## The Millbrook Power (Gas Fired Power Station) Order

### Responses to the Examining Authority Written Questions – Submitted at Deadline 2

**Applicant's response to Examining Authority's First Round of Written Questions**

**Deadline 2: 17<sup>th</sup> April 2018**

Millbrook Gas Fired Generating Station Order 201*

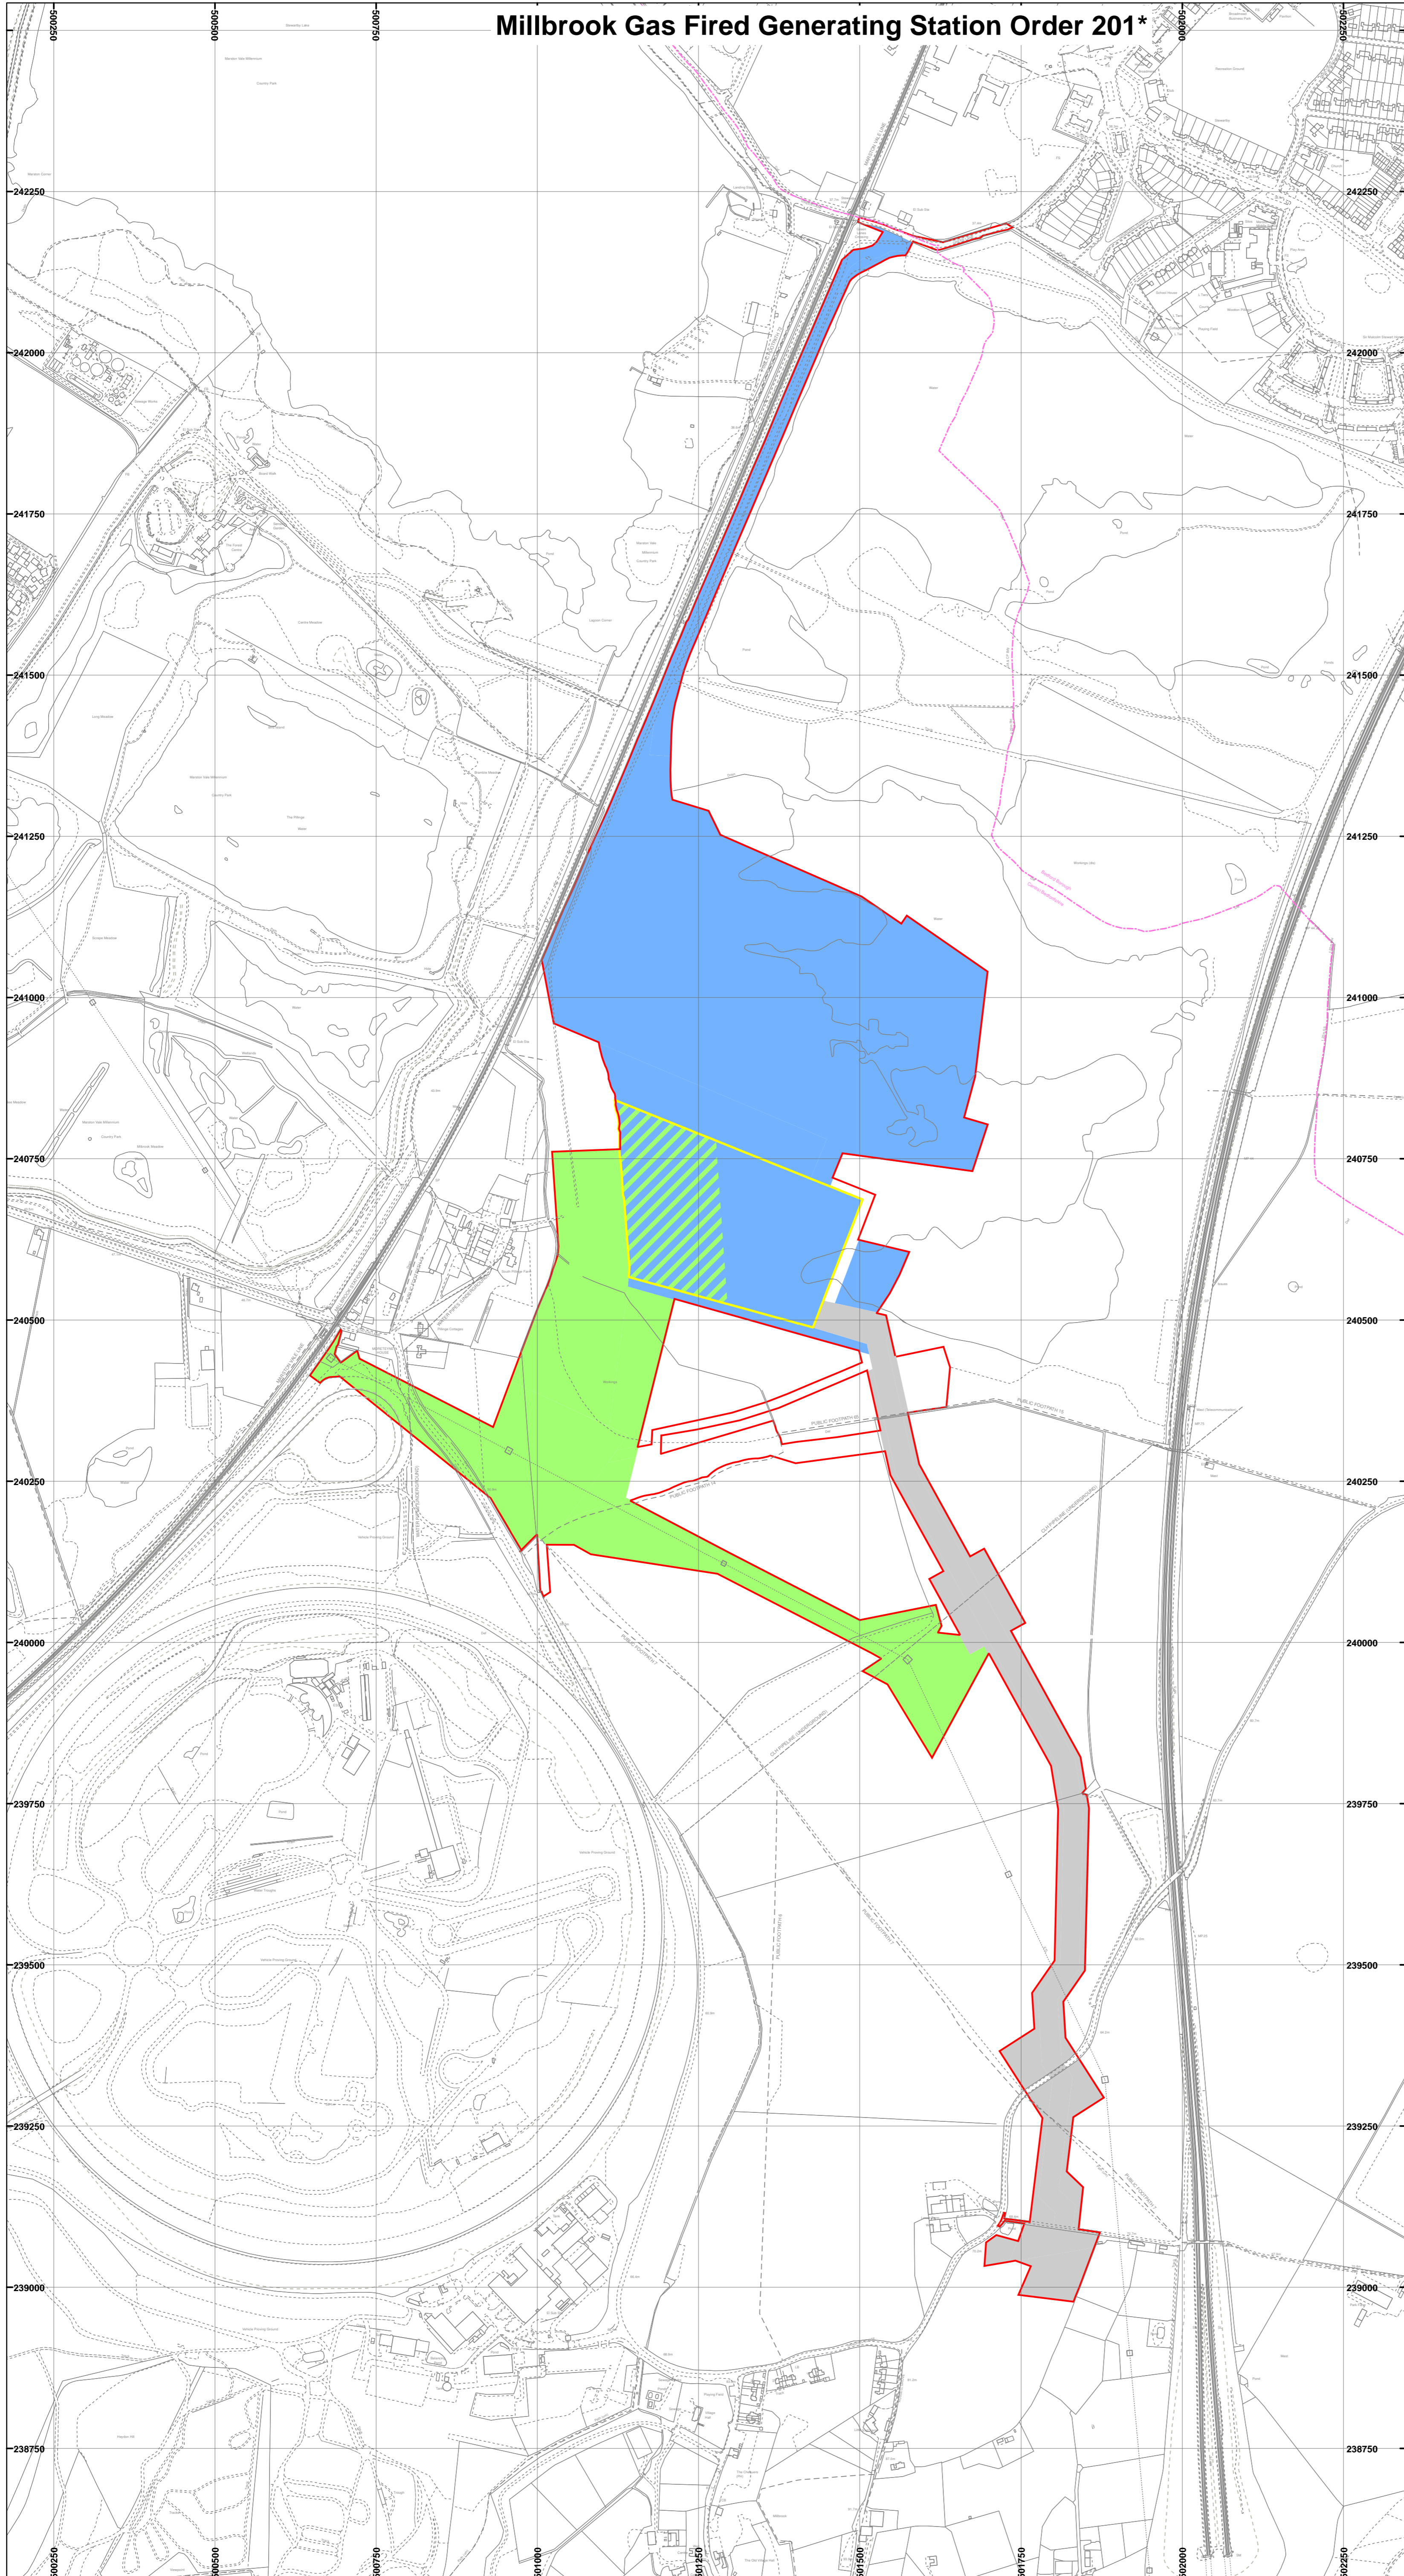
1.0.3	Applicant	Figure 1.2 of the ES shows separate coloured areas for the Generating Equipment Site, the Electrical Connection and the Gas Connection. Other areas within the Order Limits are shown in white. Please set out the reason for the inclusion of these white areas and the use that will be made of this land.
-------	-----------	--

1.0.4	Applicant	ES Figure 1.2 shows a substantial area in blue marked as the Power Generation Plant Site. The area to the north of the Generating Equipment Site appears to be land that would largely be occupied by the Covanta Resource Recovery Facility (Covanta RRF). Please explain why all of that land is included in the Order Limits. To the extent that some of this land is required in order to provide access to the Generating Equipment Site can an access corridor be specifically identified?
-------	-----------	--

1.1.28 The white area along Green Lane has been included to enable the Applicant to have the necessary street powers required to construct the Proposed Development.

1.1.29 The other white areas are required for landscaping, access and temporary use during construction as follows (referring to the plot numbers on the Land Plans):

- Plots 3\_PGP and 12\_EC are required for access.
- Plot 11\_EC is temporarily required for construction.
- Plots 2\_GC, 3\_GC, 4\_GC and 6\_GC are required for landscaping and access.

1.1.30 In the ES, the term Power Generation Plant Site includes the Access Road. The Applicant refers to its response to written question 1.12.2 in relation to the need for the Order limits to cover all of this area.

Drawn: SFS	Checked: SJS
Designed: IMC	Approved: IMC
Date: 21/08/17	Scale: 1:1250
Project Number: 70032619	Drawing Number: FIGURE 3.1 D

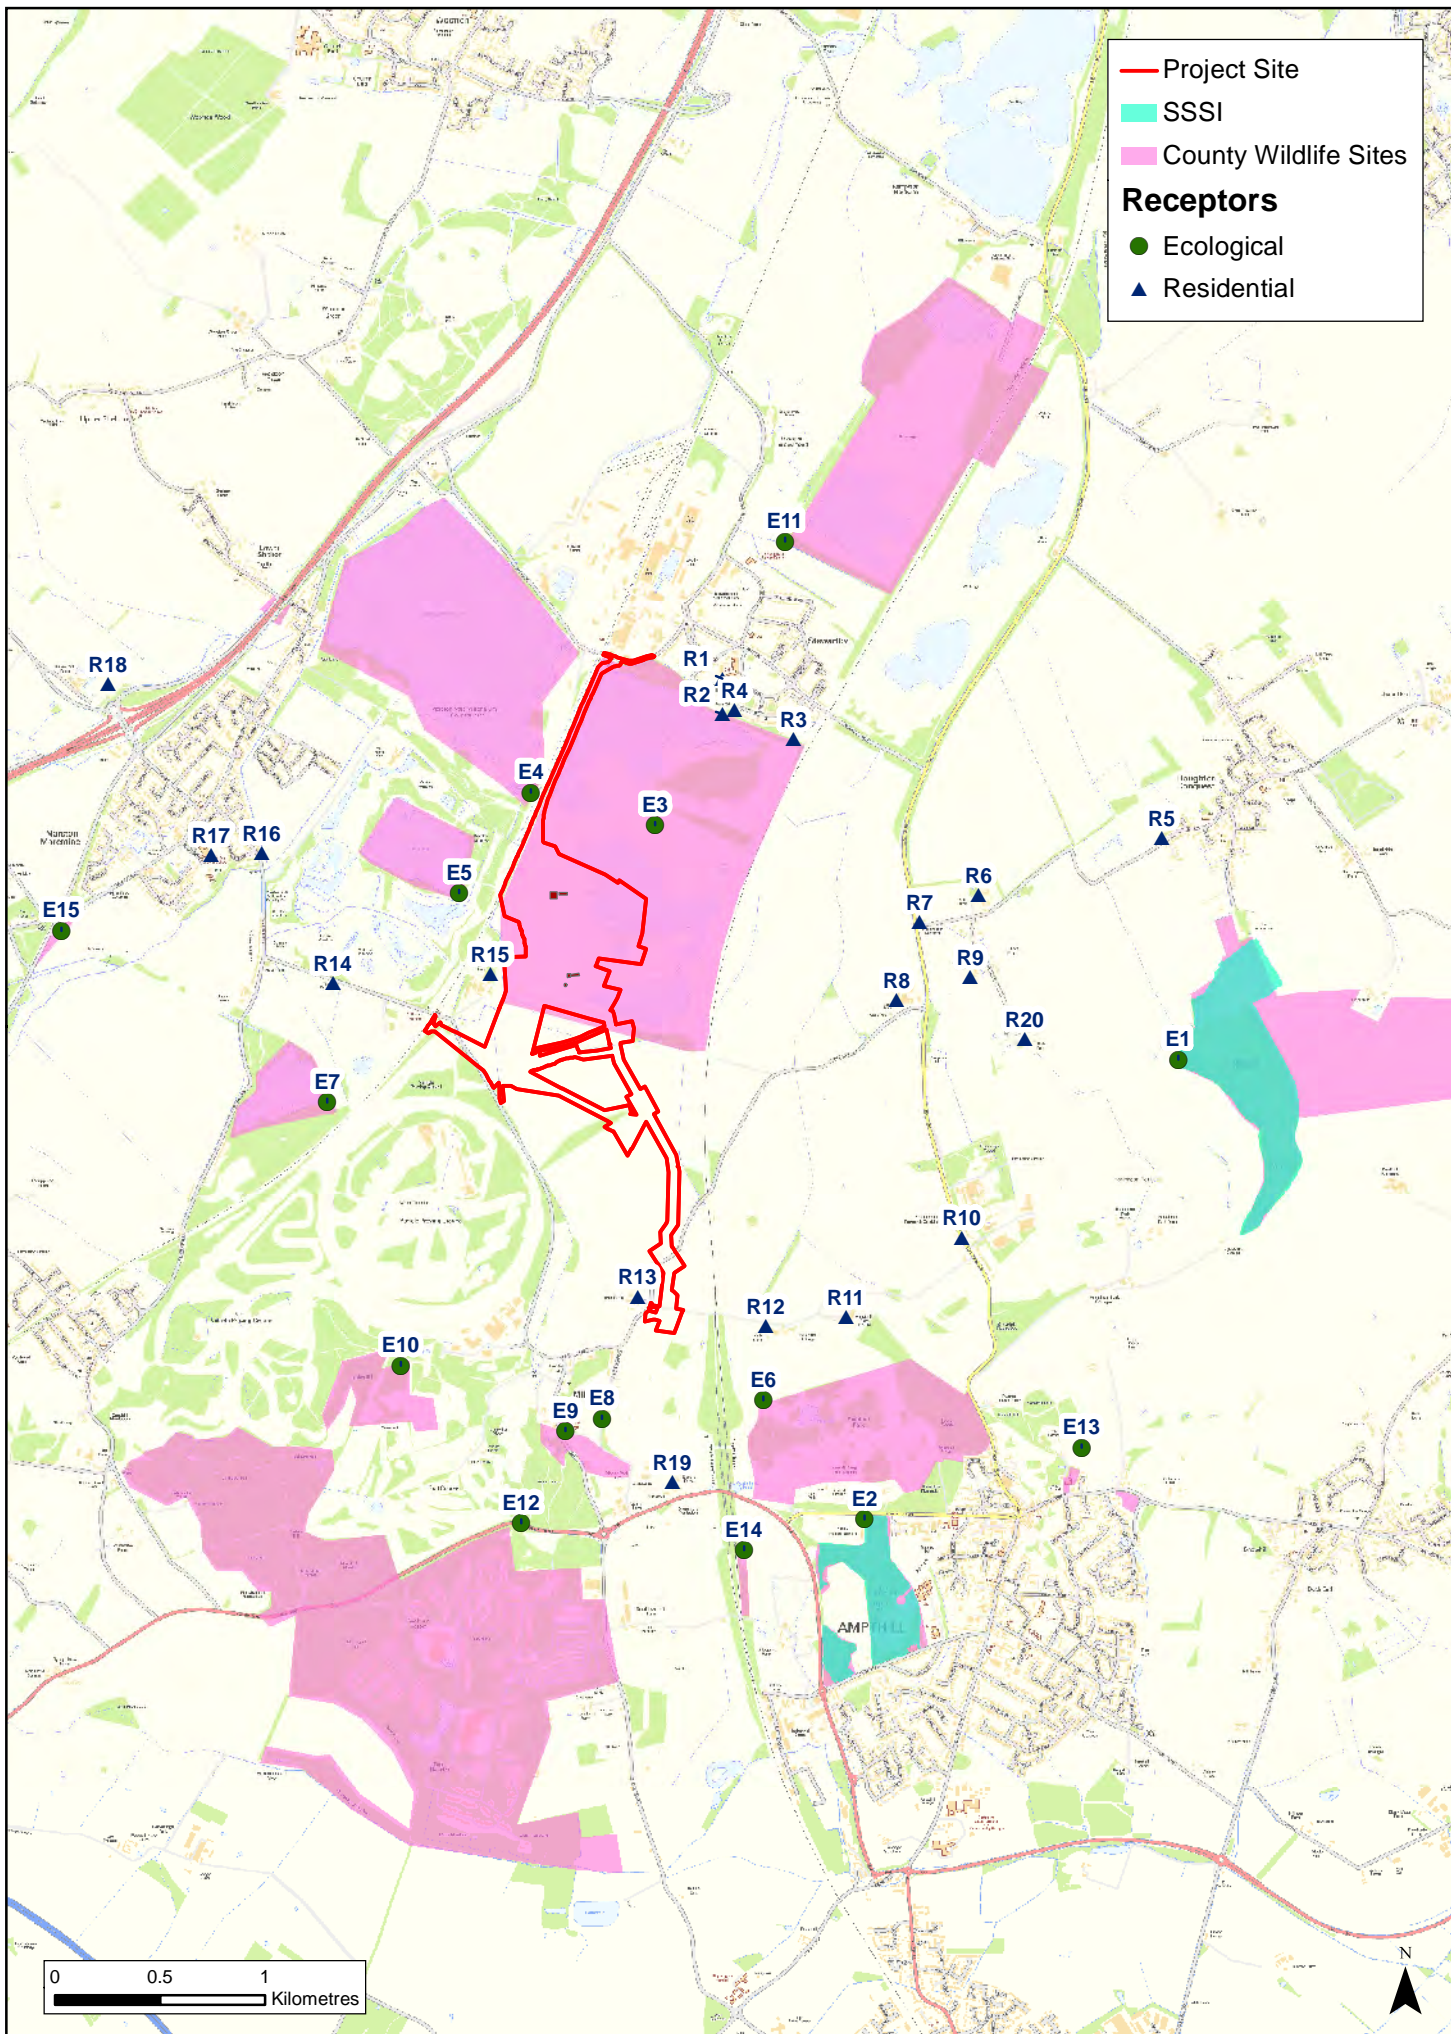
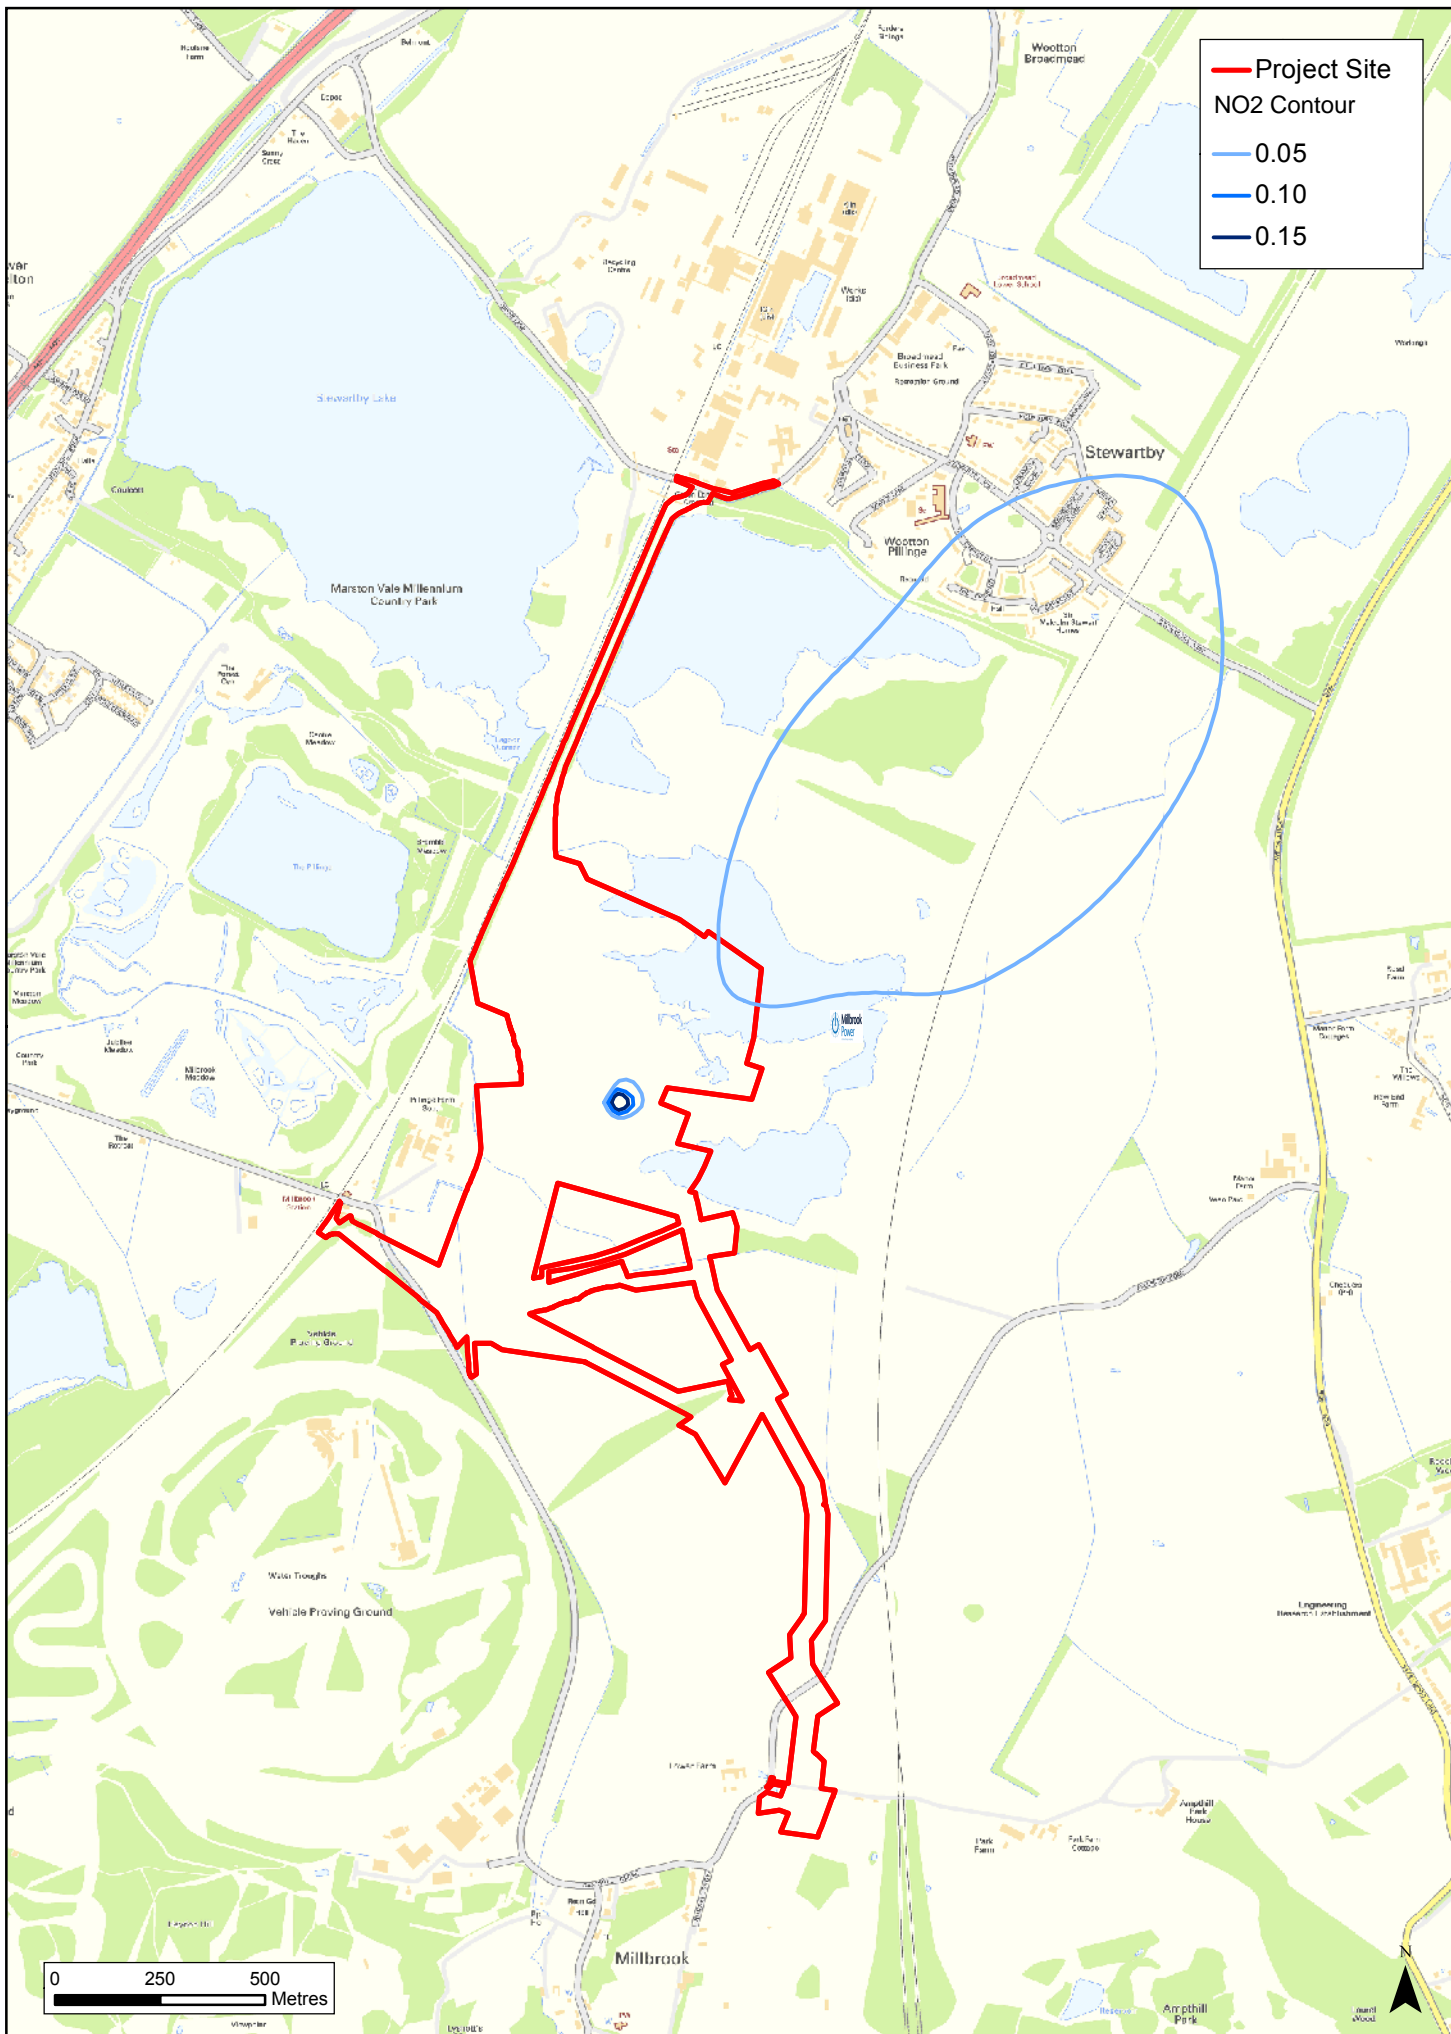
1.0.8	Applicant	ES paragraph 3.1.13 refers to road access to the site being shown on Figure 1.2 and paragraph 3.2.15 refers to a temporary construction laydown area. Figure 1.2 does not show either of these elements. Please confirm whether the access routes listed here are those shown in Figure 12.2 and the laydown areas are as shown in Figure 3.1 or provide further figures showing the details.
-------	-----------	---

- 1.1.40 Figure 1.2 of the ES [APP-049] shows the road network in the immediate vicinity of the Project Site, as well as clearly showing the access point to the Project Site from Green Lane, which was the intention of paragraph 3.1.13 of the ES. However, Figure 12.2 [APP-049] shows this in more detail, as well as highlighting the access points to the Project Site from Green Lane, Station Lane and Houghton Lane.
- 1.1.41 Although the temporary laydown area is shown on Figure 1.2, it is acknowledged that this is not clearly defined or labelled. The text in paragraph 3.2.15 is, however, referring to the laydown area as shown on Figure 3.1 where it is defined and labelled.
